September 9, 2021

John Green
El Paso County
2880 International Circle
Colorado Springs, CO 80910

Please see the responses to the comments received below.

C101

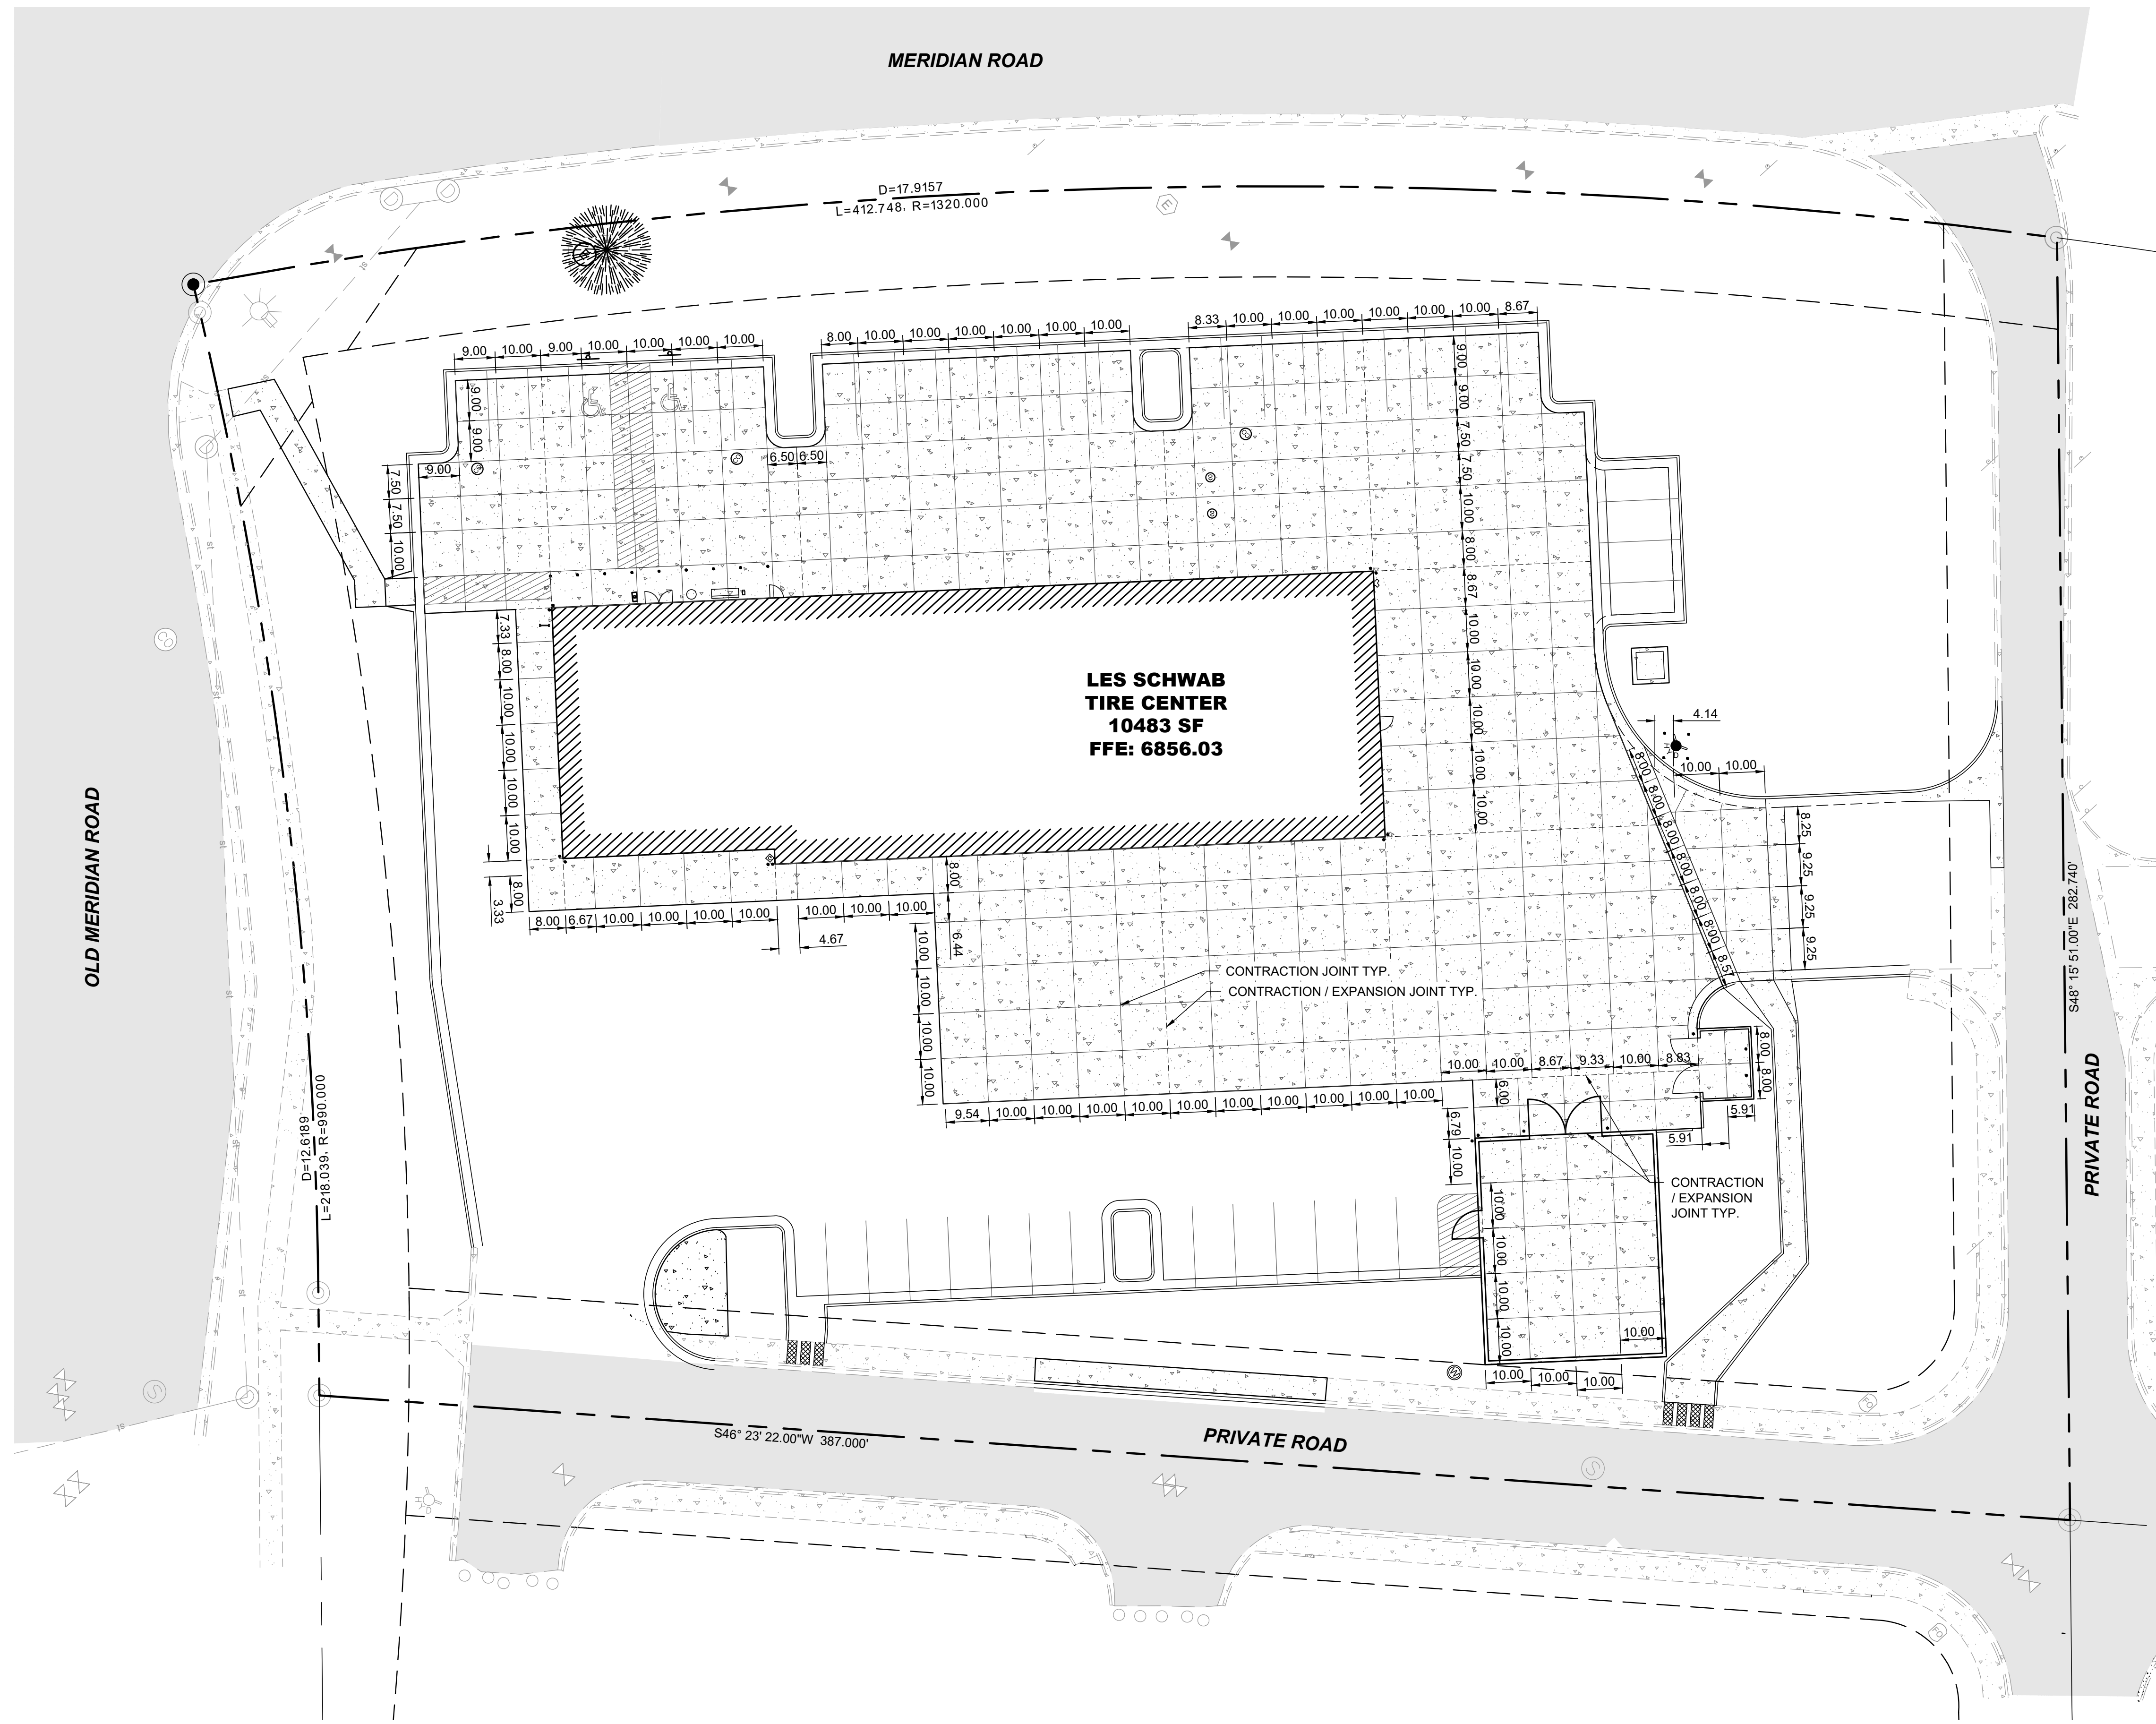
1. Show ADA access Route

Response: *ADA access route has been added and labeled on sheet C100*
